Appeal Decision

Appeal Ref: APP/R5510/D/25/3360052

51 Weymouth Road, Hayes, Hillingdon UB4 8NG

- The appeal is made under section 78 of the Town and Country Planning Act 1990 (as amended) against a refusal to grant planning permission.
- The appeal is made by Mr. Abid Shabir against the decision of the Council of the London Borough of Hillingdon.
- The application Ref is 14121/APP/2024/2846.
- The development proposed is for the erection of a part two storey, part single storey side extension and single storey rear extension.

LOFT FLOOR PLAN - 1:50

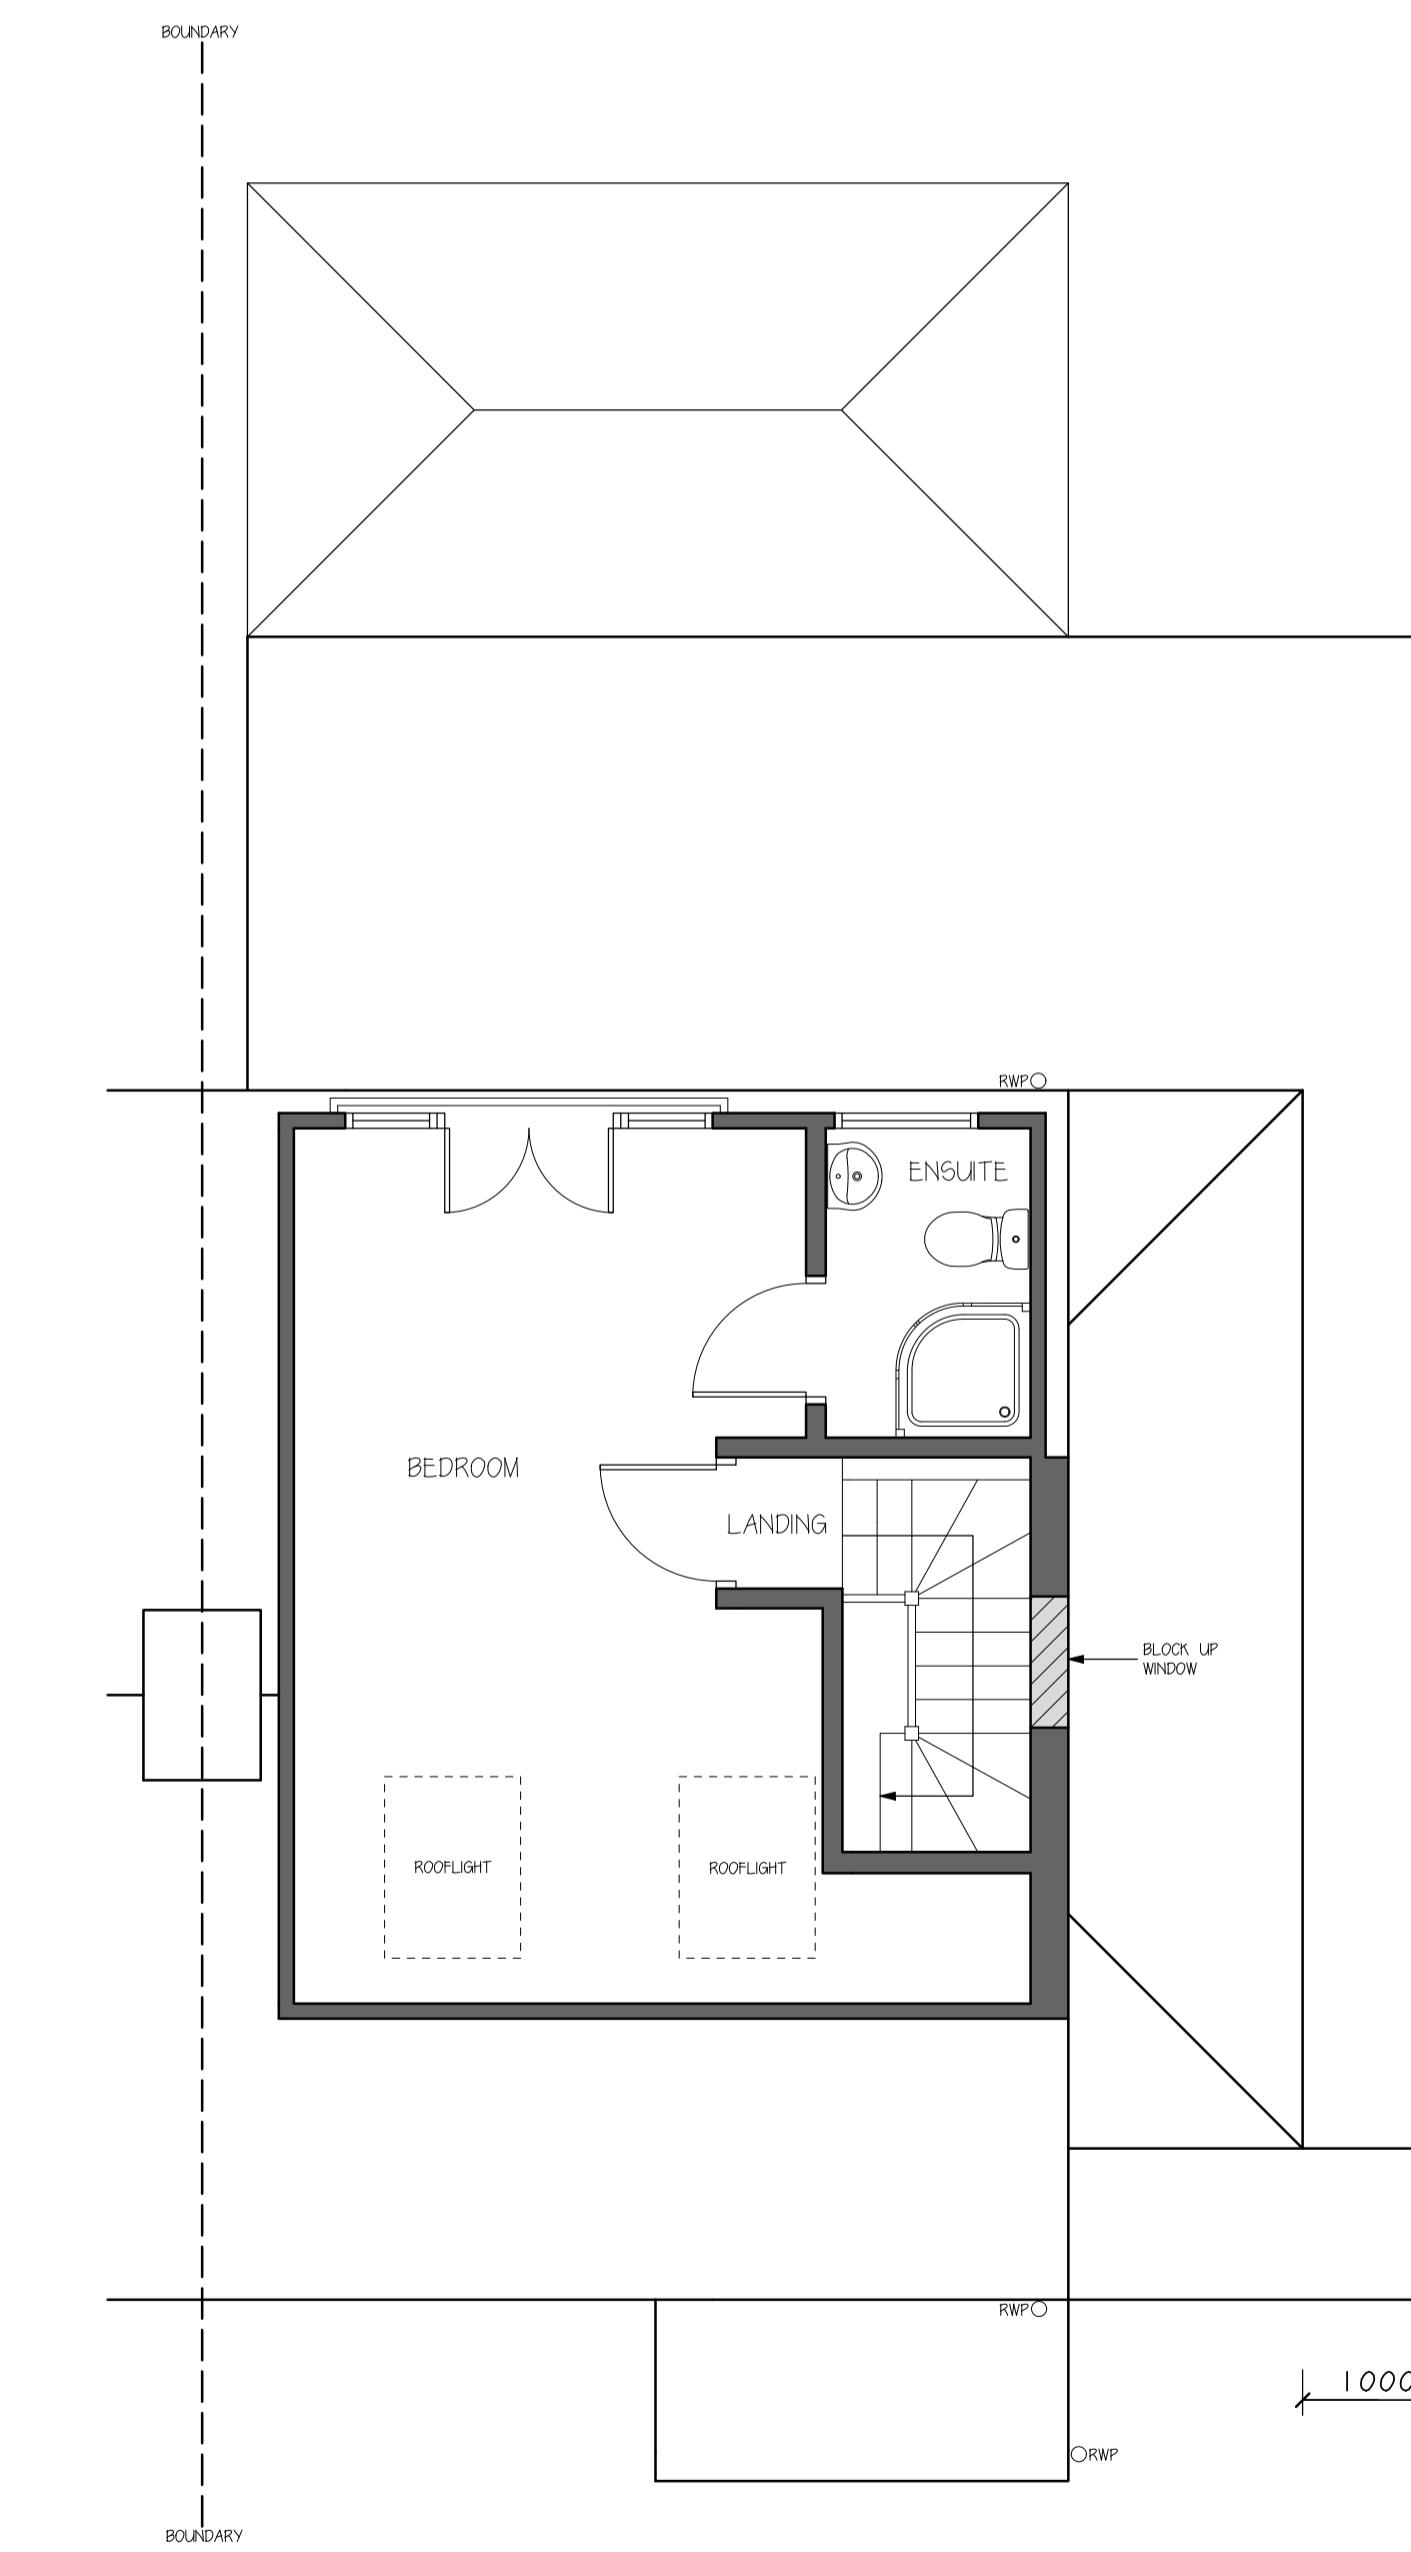
6. The proposal would not provide a one metre setback from the main front elevation and side boundary at ground floor. It also involves a two-storey side extension where a hip to gable roof extension exists. It, therefore, fails to fully comply with Part C) of Policy DMHD 1 under Appendix A of the London Borough of Hillingdon - Local Plan Part 2 2020 (LP P2).

7. Whilst the setbacks at ground floor would not be achieved, this is already the case with the attached garage. The one metre setbacks would also be provided at first floor. These, together with the existing wide gap and the appeal building's positioning, would ensure that the regular rhythm of gaps is maintained along the street scene. Additionally, the proposal will have a slim appearance and would not exceed the width limits of Part C). The ridge height would be well below the main ridgeline with matching eaves. Due to its subordinate size and use of matching materials, it would integrate well with the host dwelling. The proposed hipped roof design would also complement the surrounding original hipped roofs.
